**WEST SUSSEX COUNTY COUNCIL
STRATEGIC PLANNING CONSULTATION**

SUBJECT: AW/14/15PL – Change of Use of existing lounge/dining area to retail (A1 Shops) together with new residential extension to rear.

19 Rose Green Road, Aldwick, Bognor Regis

SITE BLOCK PLAN [1:500]

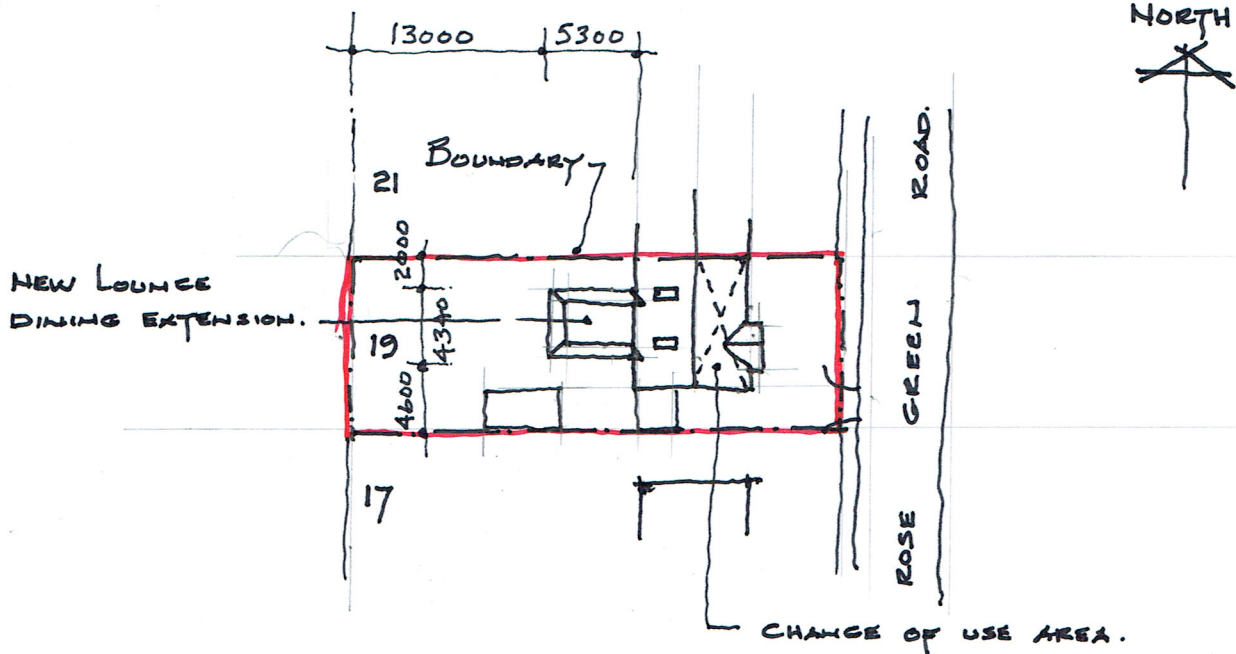
Apart from the internal changes to create a shop floor (28sqm), and new residential extension, no changes will be made to the access of the property. The access drive leads to 3 car parking spaces, and there is also plenty of on-street parking should the shop attract more than 3 customers in any given period.

Visibility from the existing access is good; depending on the type of vegetation in place along the front wall it may be necessary to keep this as low as the wall to encourage forward visibility into the parking area from the highway.
